Planning Application 03/2024/0096

I am writing with regard to the proposed vehicular access from Little Lane onto the grounds of Longridge High School.

Access Detail (Scale 1:200)

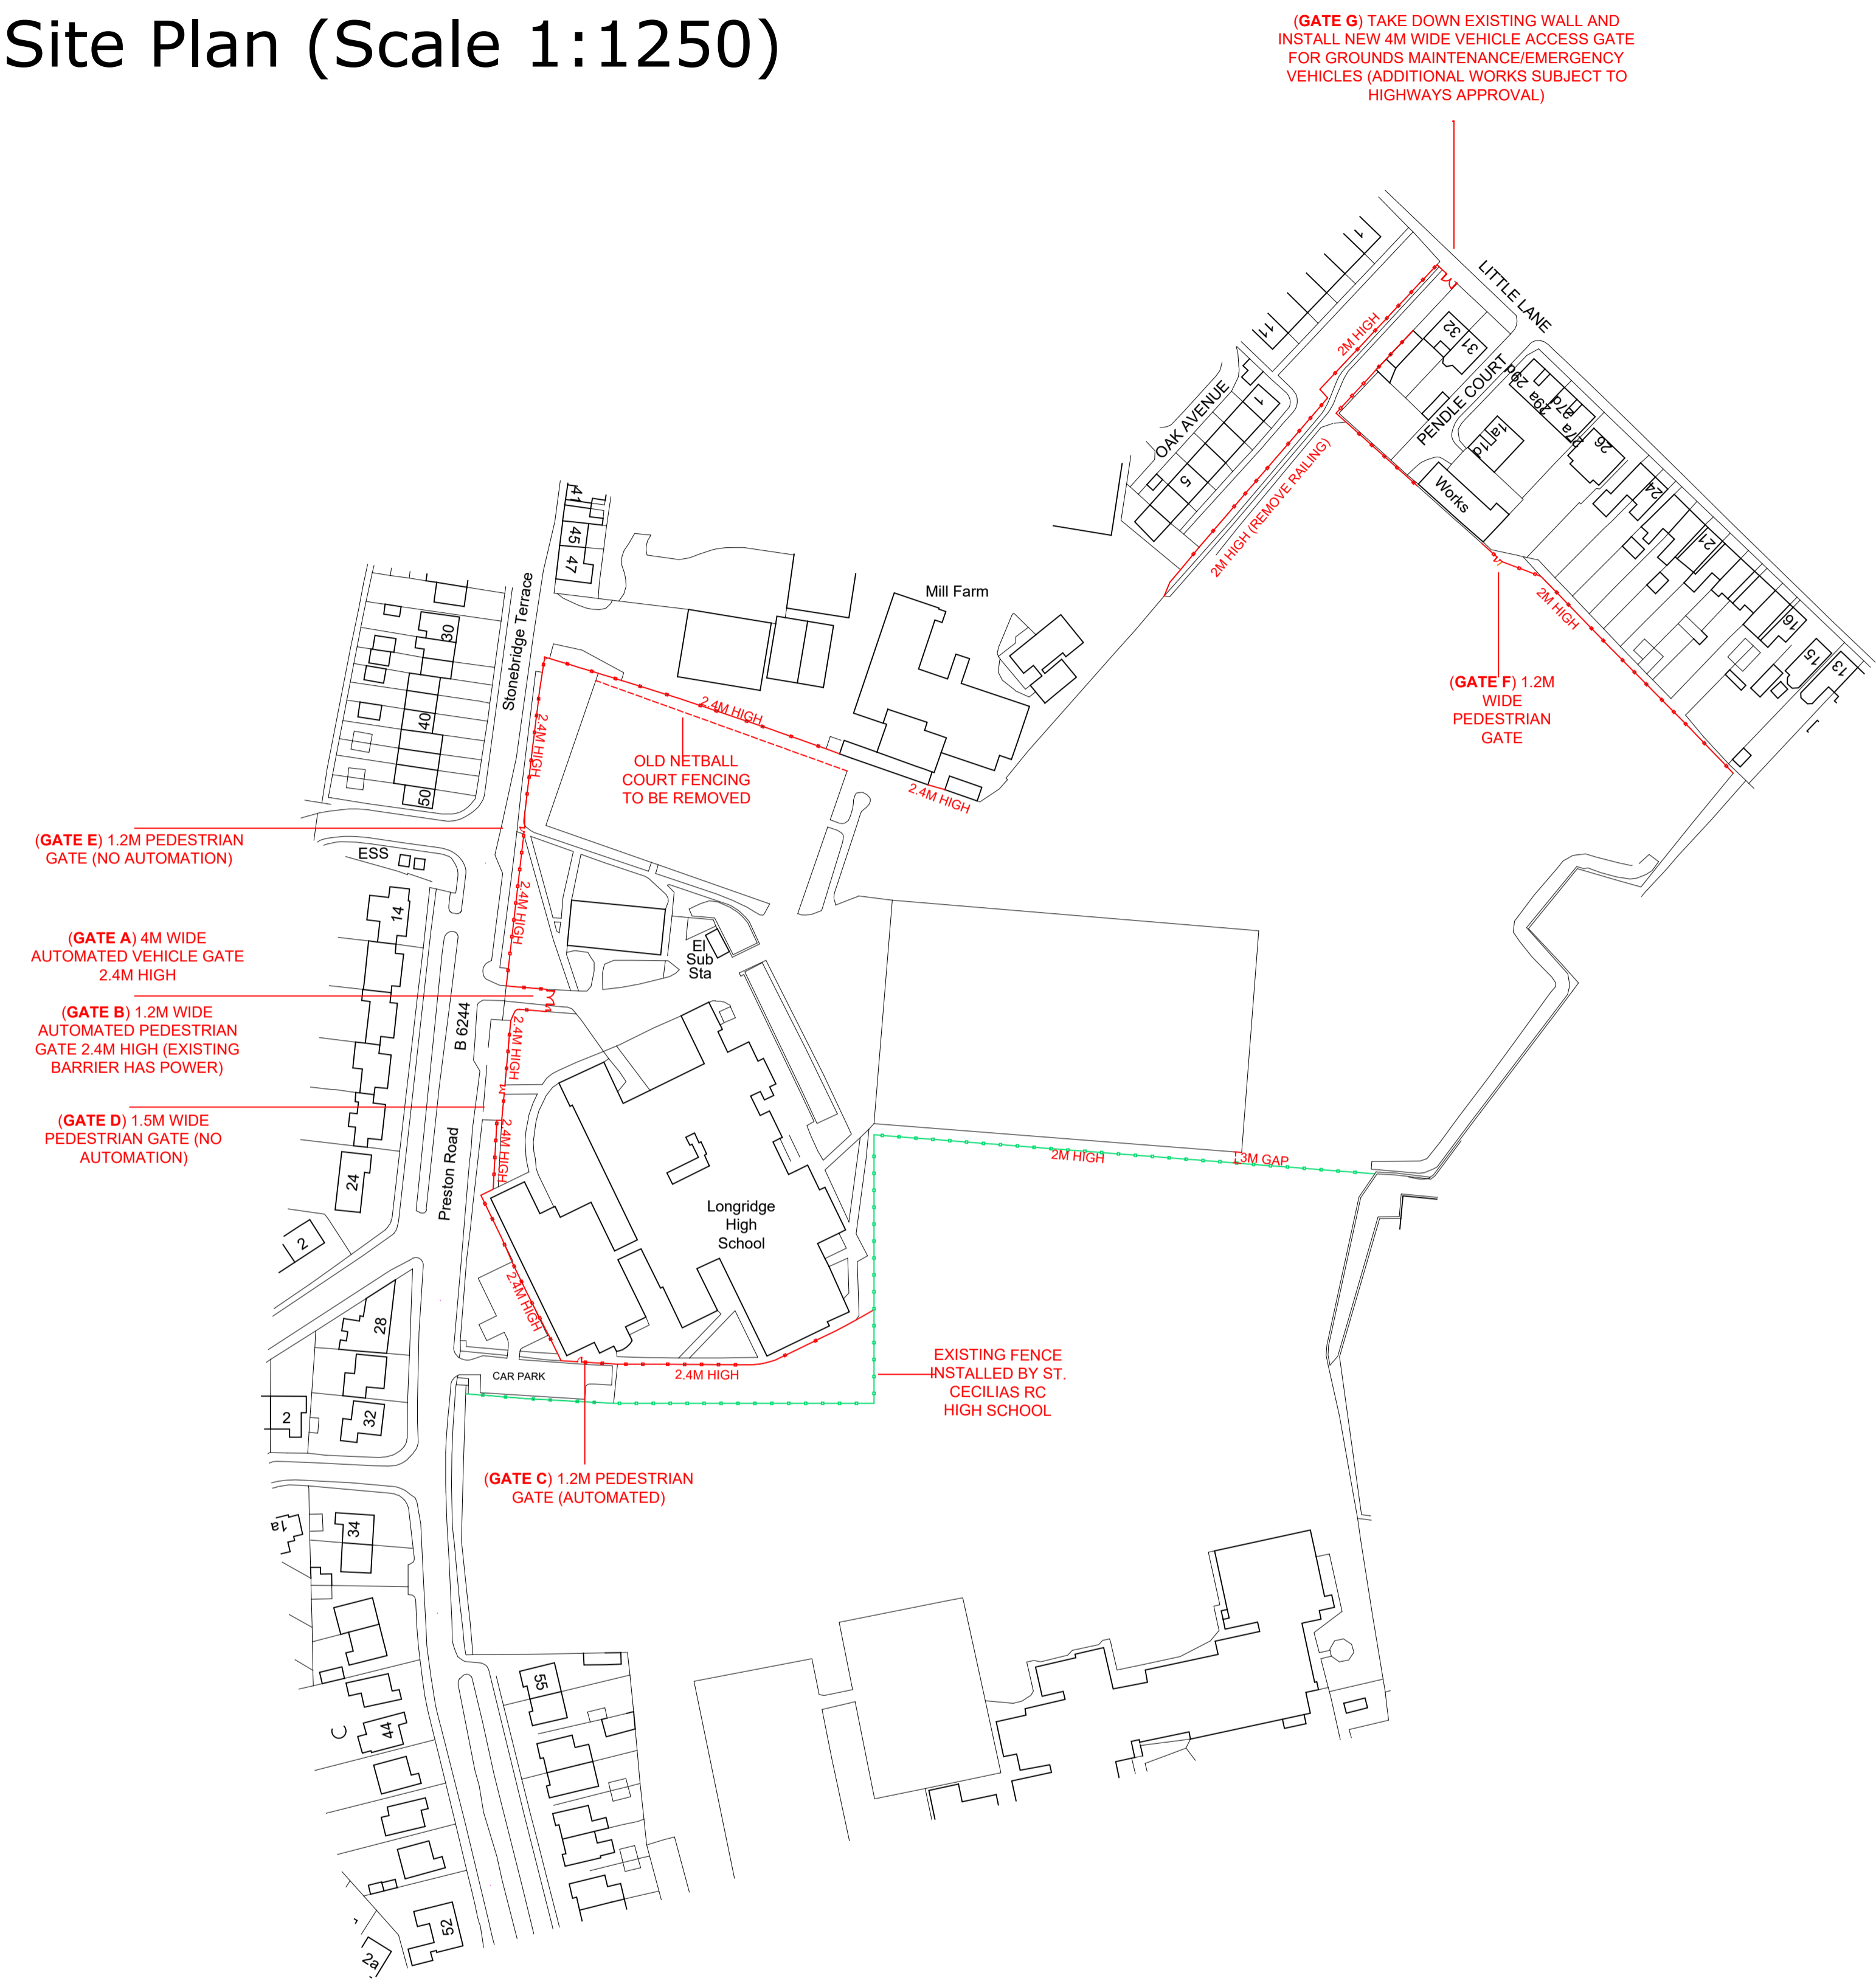
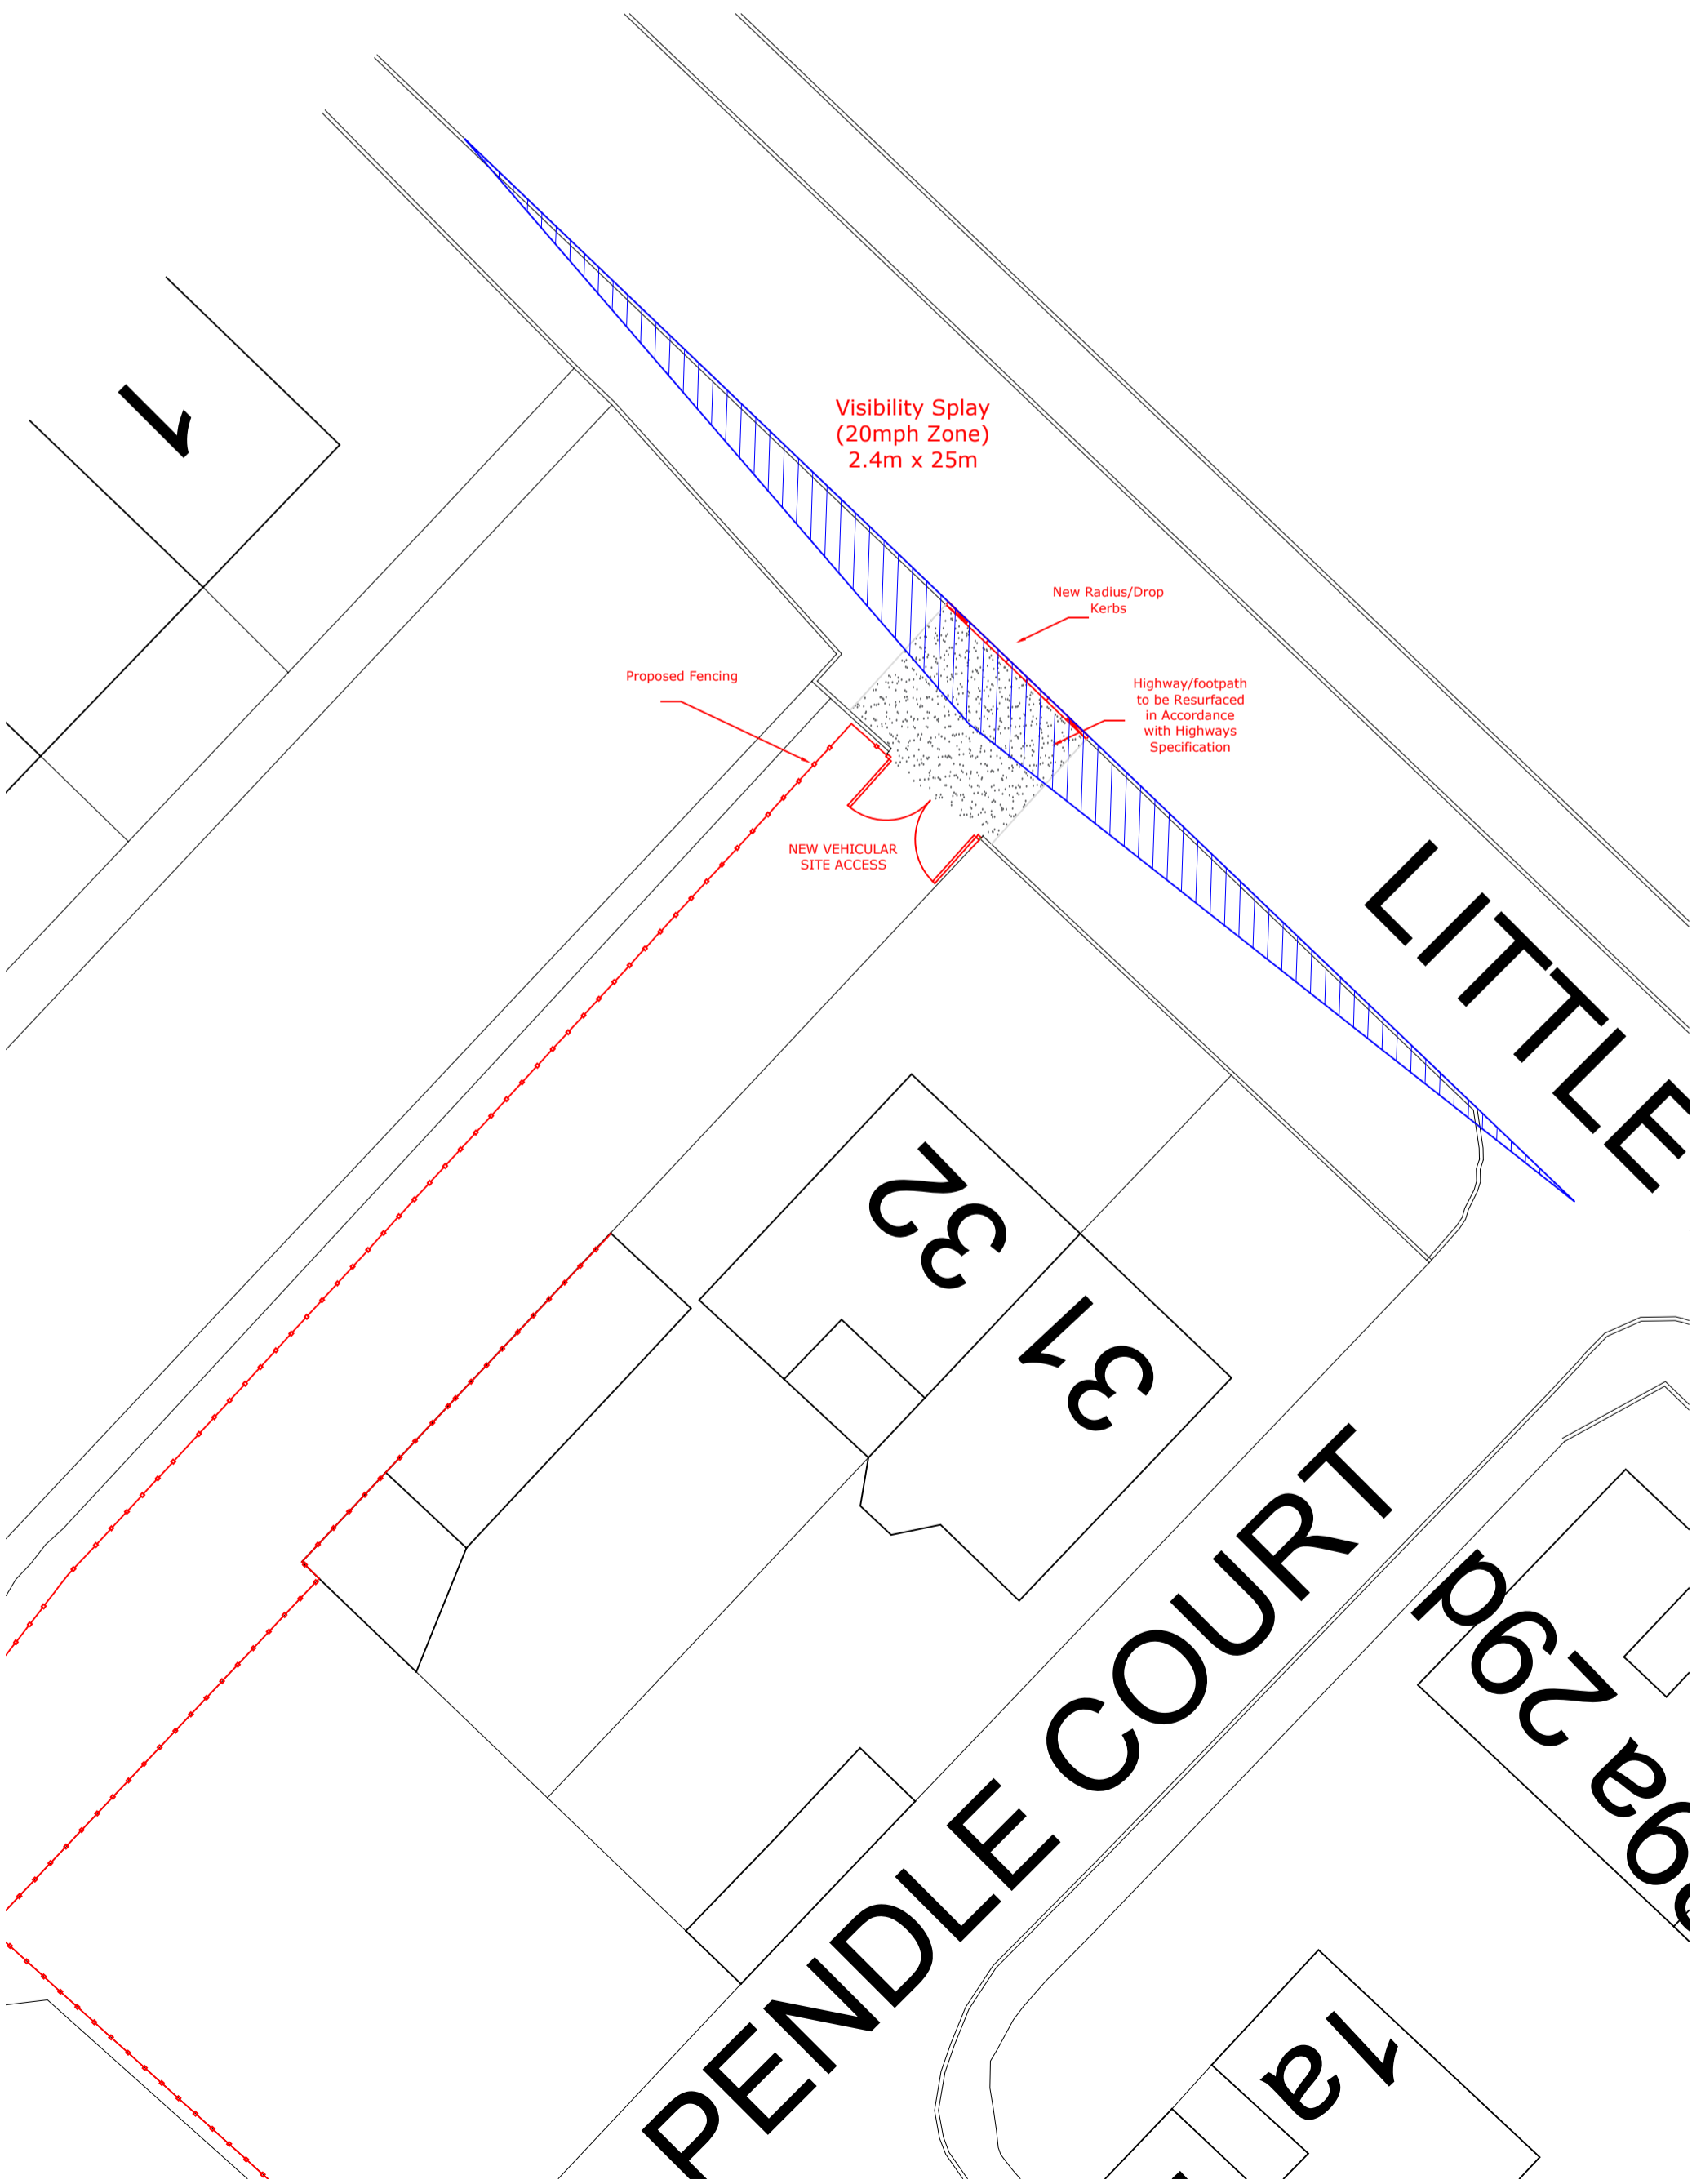
I oppose this in the strongest possible terms based on the fact that the traffic situation is currently horrendous and any further traffic will exacerbate what is already a totally unsatisfactory situation. Due to the fact that the majority of the houses on Little Lane are terraced, without driveways, cars are constantly double parked down the entire length of the lane meaning that moving traffic has to negotiate, what is in effect a single track, down the middle of the lane. Hence when, vehicles meet head on, the congestion does not only cause massive inconvenience but it increases the level of danger for both motorists as well as pedestrians. Therefore, to encourage further traffic is an ill thought out scheme.

Further to this, with cars parked opposite and adjacent to the proposed entrance, accessing the school grounds for motorists would be very restrictive as well as dangerous. There will be blind spots and this will make crossing the entrance way treacherous for pedestrians.

The increase in vehicles which at times will be stationary, will increase the levels of pollution in what is a residential area. Has this proposal really been thought through, especially at a time when we are all told to consider the environmental impact of our actions?

All in all, this planning application, or, at least the aspect concerned with vehicular access from Little Lane, should be dismissed as it will impact negatively on the safety and well being of motorists and residents alike.

Photo 4 highlights the restrictions/ dangers should a vehicular entrance be constructed. Further to this, it would limit the parking for current residents and their guests - one can see that every bit of the lane is utilised for parking as it is.
